Ref No: SSD 9649/D04356721

Randwick City Council response to Mod 4 application to modify the consent for Doncaster Avenue Student Accommodation (SSD 9649).

Randwick Council wishes to make the following comments relating to the proposed modifications to the approved development under SSD 9649 Mod 4:

Drawing Title
DETAIL FLOOR PLANS-10&12
DONCASTER AVE

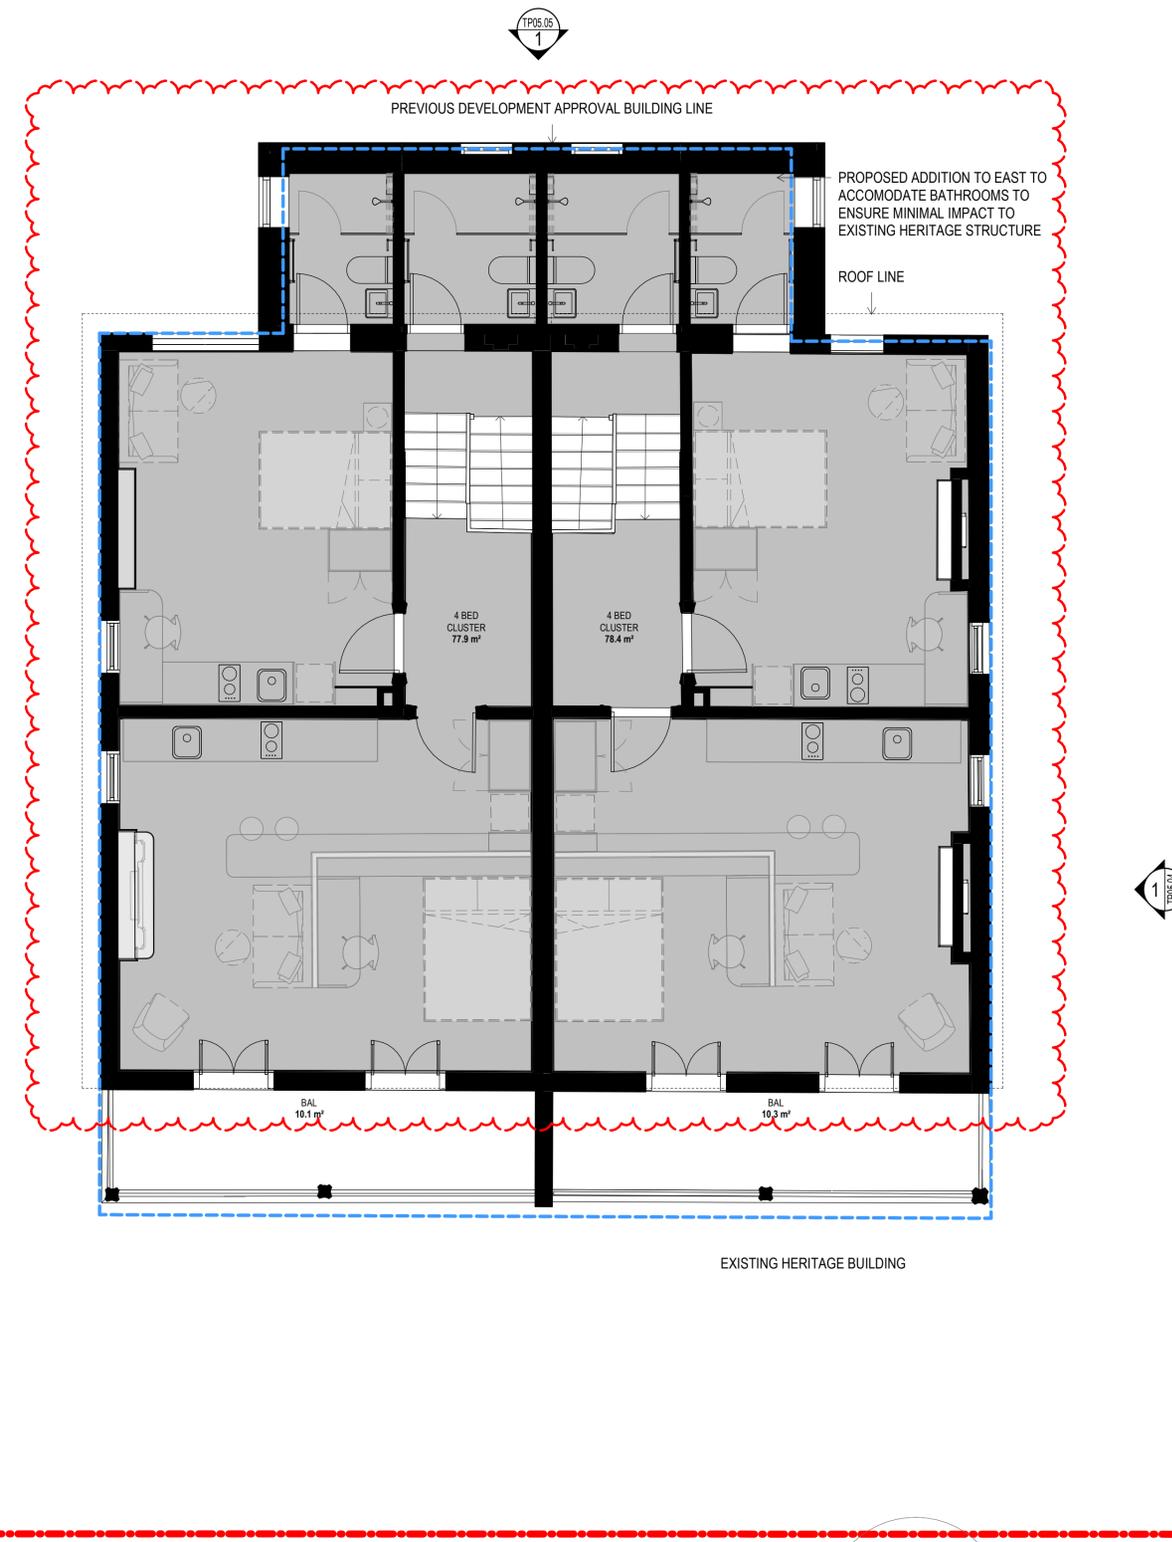
2. Amendment to the Doncaster Terraces heritage item by way of alterations and additions to the rear to provide for upgraded bathrooms at ground and first floor level.

There are no heritage objections to the proposed changes to the new building, which will not alter the building envelope. In order to increase the number of apartments and to provide self-contained bathrooms for each, changes are proposed to the heritage item. Externally, it is proposed to marginally increase the width of the bathroom additions, and to increase the height of the bathroom additions by around 1.1m (two bathrooms accessed from upper floor and two bathrooms accessed from stair landing).

The proposed bathroom addition will retain a flat roof, and which will be lower than the eaves height of the heritage item. The proposed bathroom addition will remain secondary to the original heritage fabric and its streetscape visibility will not be increased. Internally, an additional opening will be required at ground floor level and two new openings will be required at first floor level, resulting a loss of original fabric including brickwork and skirtings. The loss of fabric will be minor and affect the rear of the building which has been subject to previous changes, including demolition of the rear wing. The proposed internal changes related to the bathrooms and the creation of two additional apartments will not affect spatial configuration or original detailing of the main rooms.

The mitigative measures provided by artefact should be included as consent conditions:

- The approved materiality for the rear addition should not be amended
- Where possible, salvage any timber skirting boards for reuse within the building; this includes repurposing the timber for the proposed opening architraves
- Where possible, salvage brickwork for reuse with the item, particularly where evidence of external damage is apparent or missing bricks are required for infill
- The removal of the brickwork should be conducted using hand tools to avoid inadvertent direct (physical) impacts
- Protect original timber flooring elements before demolition works using protective sheeting

Drawing Title
ROOM TYPES

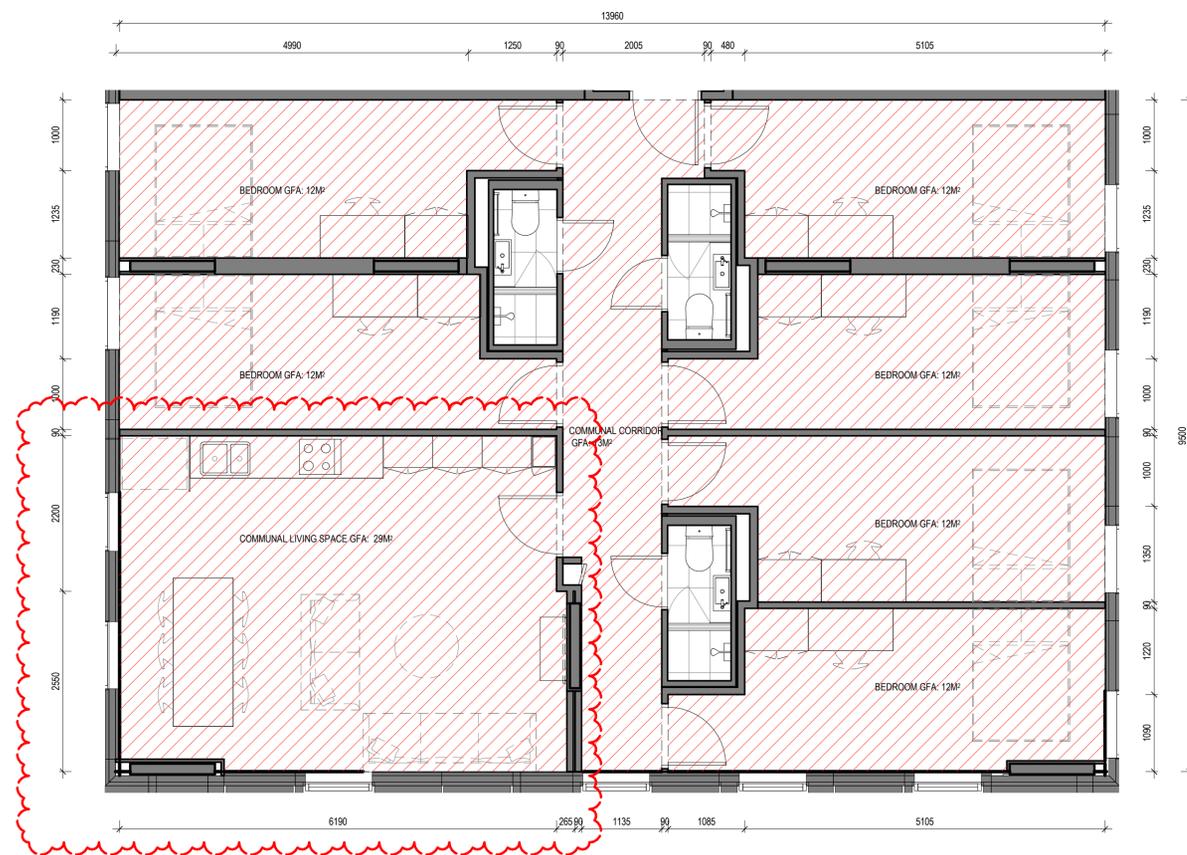
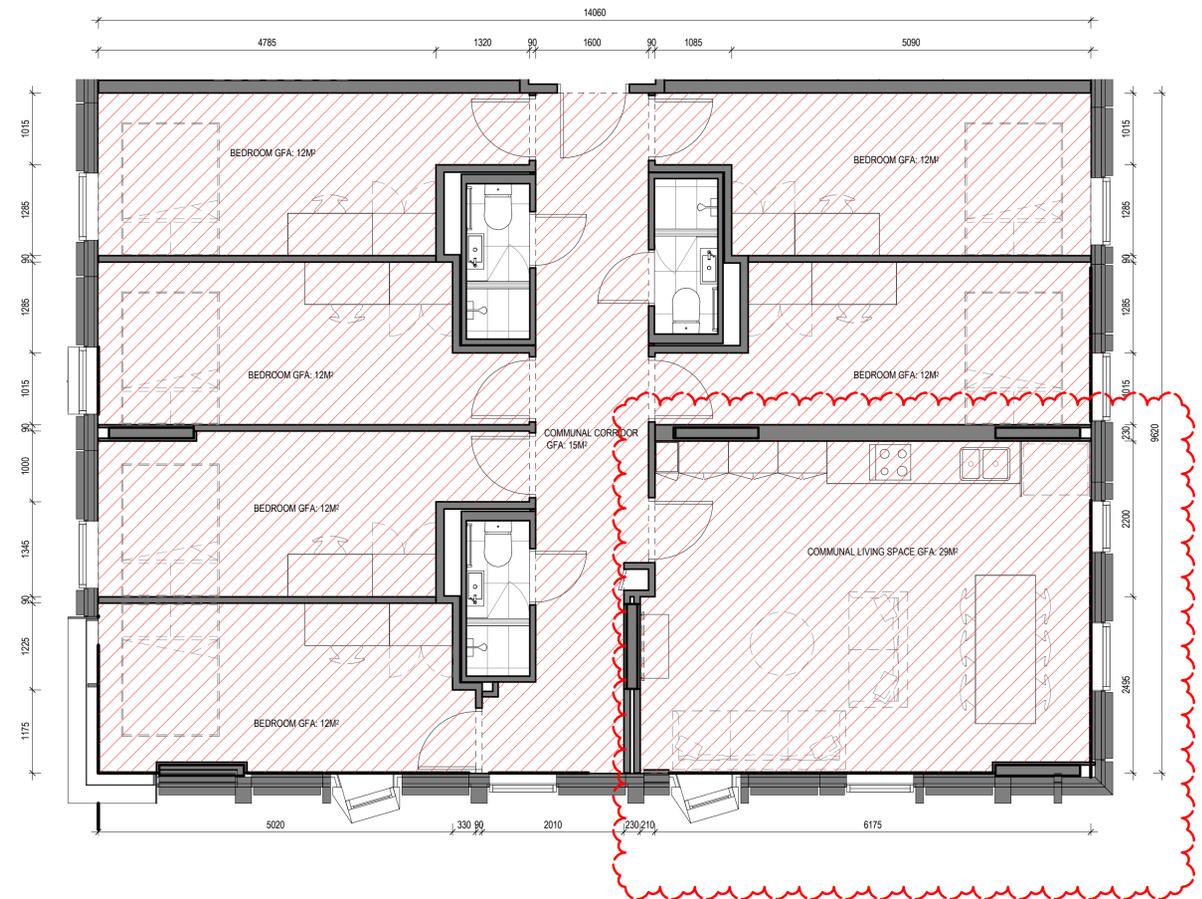
1. Redesign of the five 7 bed clusters into 6 bed clusters.

Council does not object to the rearrangement of 7 bed cluster rooms approved into the proposed 6-bed cluster rooms, reducing the total number of beds by 5 down to 254 student accommodation beds, as it provides for larger living rooms within the cluster rooms arrangement and therefore better amenity for future occupants of these cluster rooms arrangements.
